**KIRKLEES METROPOLITAN COUNCIL
INVESTMENT & REGENERATION SERVICE**

DELEGATED DECISION TO DETERMINE PLANNING APPLICATIONS

Reference No:	2025/62/92804/E
Site Address:	223, Wakefield Road, Earlsheaton, Dewsbury, WF12 8ER
Description:	Erection of first floor side extension
Recommending Officer:	Jennifer Booth

DECISION - REFUSED

Proposed East Elevation. Scale 1:100 (Rear side)

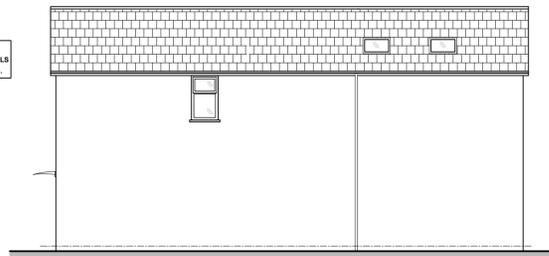
The proposed first-floor side extension does not incorporate a set back or set down from the original dwelling. As a result, the width of the extension would fail to appear subservient to the main house and would create an incongruous addition to the property. Although the use of matching materials has been proposed, this does not mitigate the overall impact on the character of the dwelling. Consequently, the side extension is considered unacceptable in terms of visual amenity.

Having taken the above into account, the proposed first-floor side extension would not be subservient to the host dwelling and, due to its width and lack of set back or set down, would result in the formation of an incongruous feature that fails to respect the character of the existing property. This design

The extension would run along the boundary with the adjacent dwelling to the east which has their rear elevation and garden area parallel to the site of the proposed extension. Given the height and projection, there would be significant overshadowing and overbearing impact. It is noted that there are no windows which could result in any loss of privacy.

PROPOSED FIRST FLOOR PLAN, SCALE 1:50

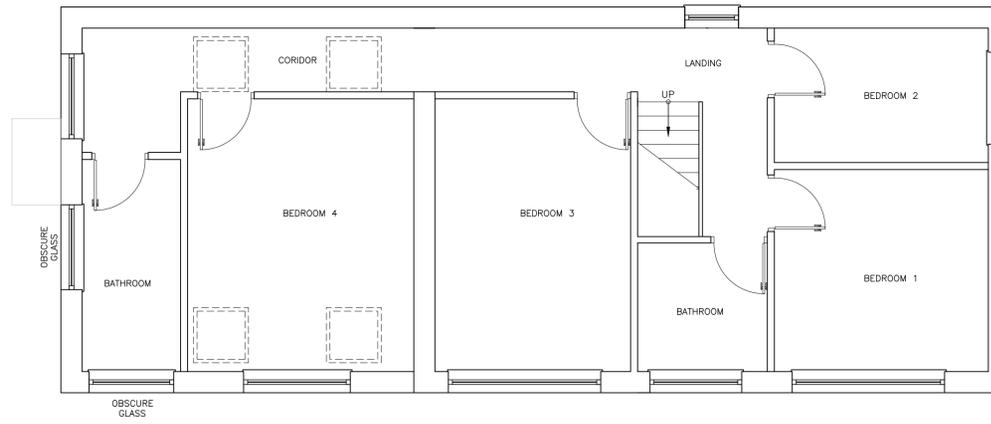
The extension would be built over the existing ground floor extension with a width of 4.6m and the full depth of the dwelling with a pitched roof form.

BLOCK PLAN (PROPOSED), 1:200

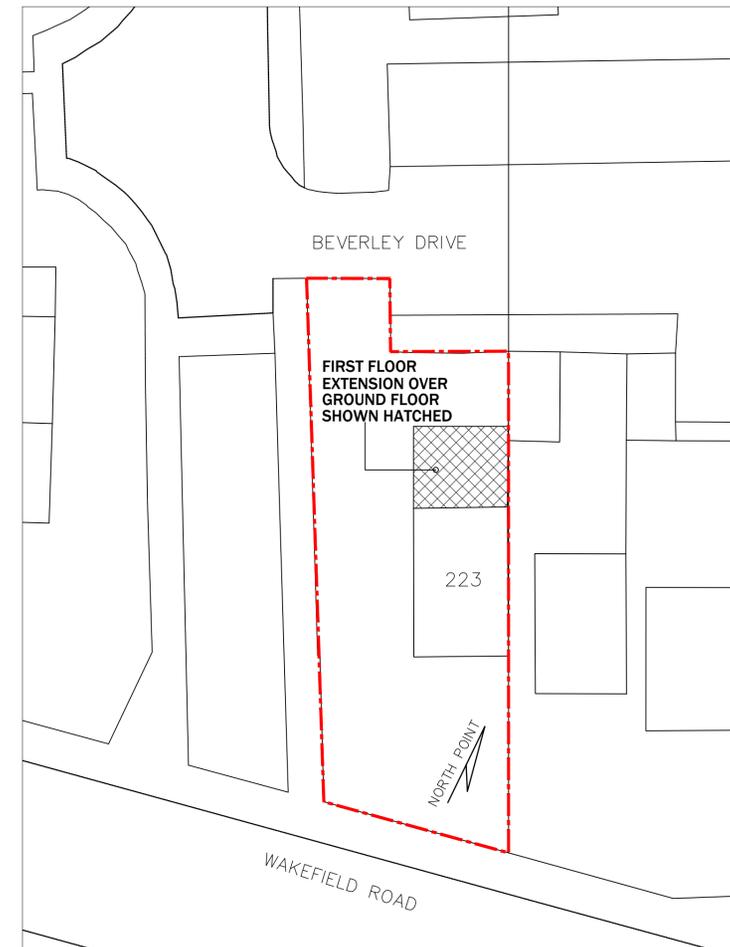
The proposed extension, by virtue of its scale, position, and proximity to the shared boundary, would result in an overbearing impact on the adjacent dwelling, reducing the sense of openness between properties and adversely affecting the outlook from neighbouring habitable room windows at the adjacent 225 Wakefield Road. This would lead to an unacceptable level of harm to the residential amenity of the adjoining occupiers, contrary to Policy LP24 of the Kirklees Local Plan, part (b), which seeks to protect the amenity of neighbouring properties, and the guidance contained within the House Extensions & Alterations SPD for KDP5 & KDP6.
